Date: 10th July 2024

Kirklees Council – Planning Applications: 2024/91316 and 2024/91317

1 PROPOSED SITE LAYOUT  
1 : 500

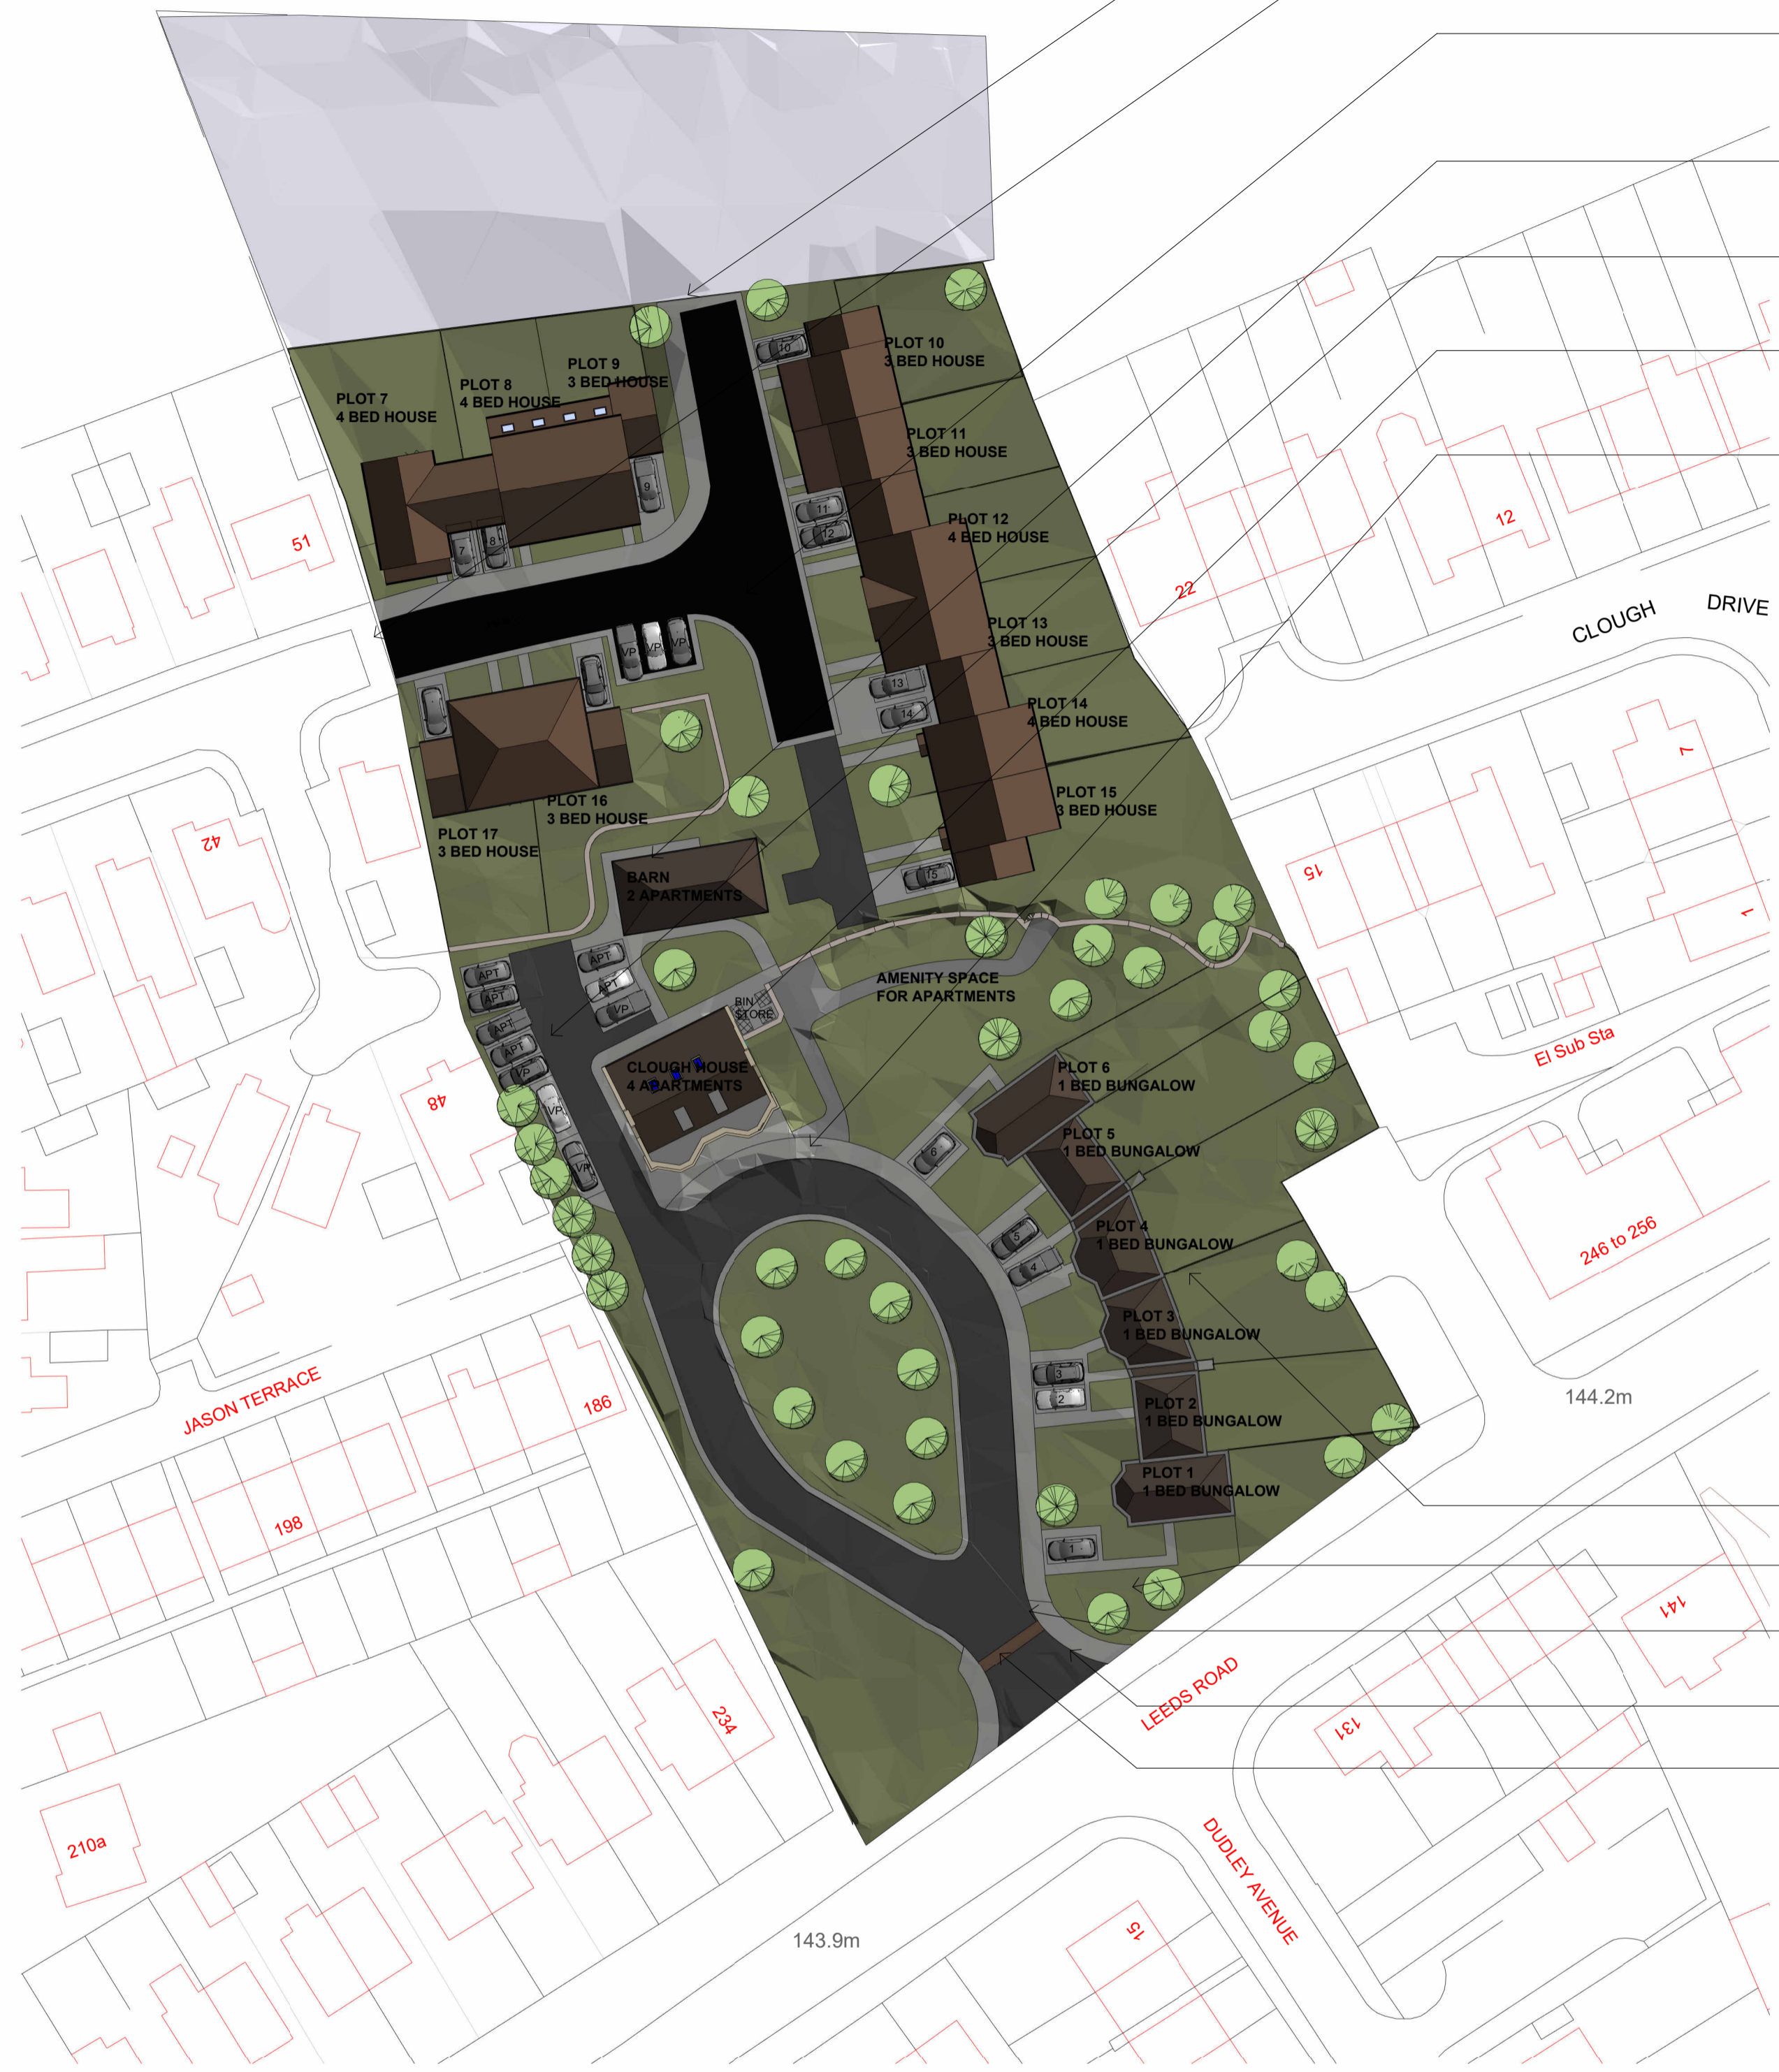
What I do object to is the access via Moat Hill Farm Drive. There is currently no access to the site from here (it states in the plans there is) as it is a cul-de-sac location with a pedestrian pavement all around the cul-de-sac enclosed with a solid wooden fence, behind this is the boundary wall and has been like this since they were built back in the 1990's. The proposed access/entrance also goes over where my boundary line is on the land registry (of which I have already sent to the council). The residents, most of who have lived on the street since the houses were built, bought them as they are in a quiet cul-de-sac location.

I sincerely object to idea of the access to the new development and opening up of Moat Hill Farm Drive as it would only add to the already congested traffic we currently deal with on a daily basis. I do support the development for the build of new houses however I would like to know which of the home are in the affordable housing scheme?

You can see below the site already has access from Leeds Road and a road on site which can access the whole area of development.

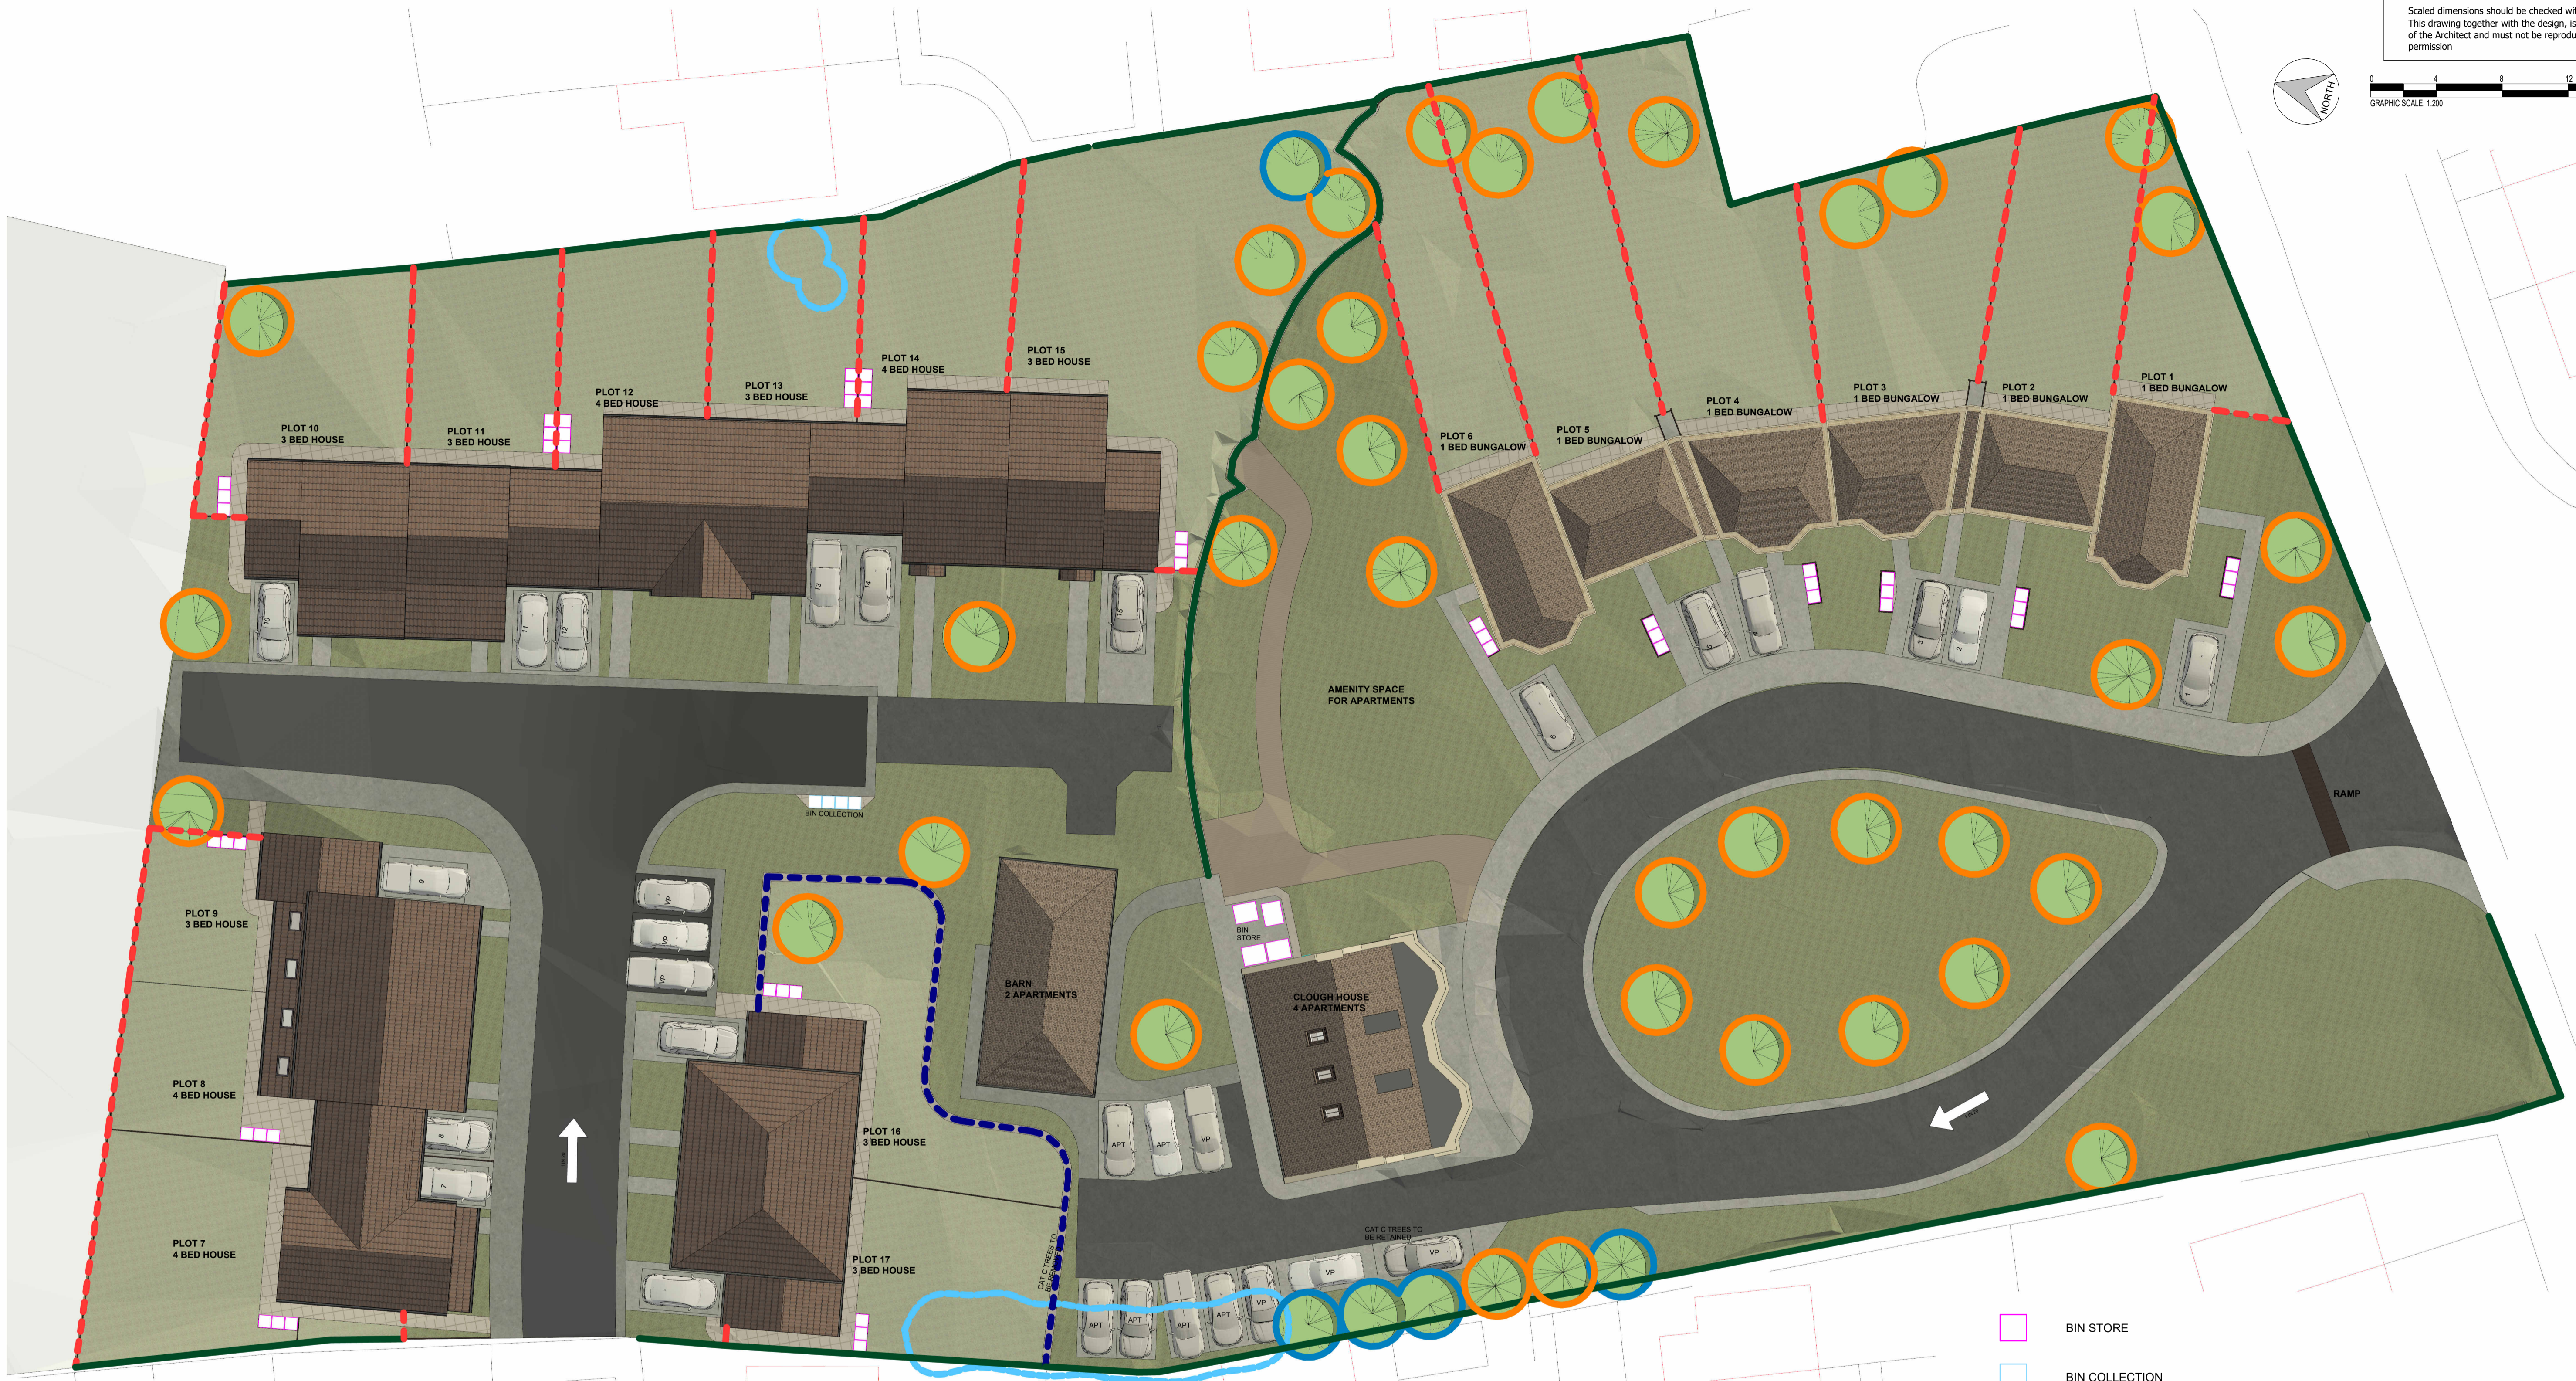
Also, I want to keep the privacy of my garden from the site with the existing trees that are well established and are home to wildlife and bats that are regularly seen, if this is not going to be left then what screening will be put in their place at a height to keep the privacy?.
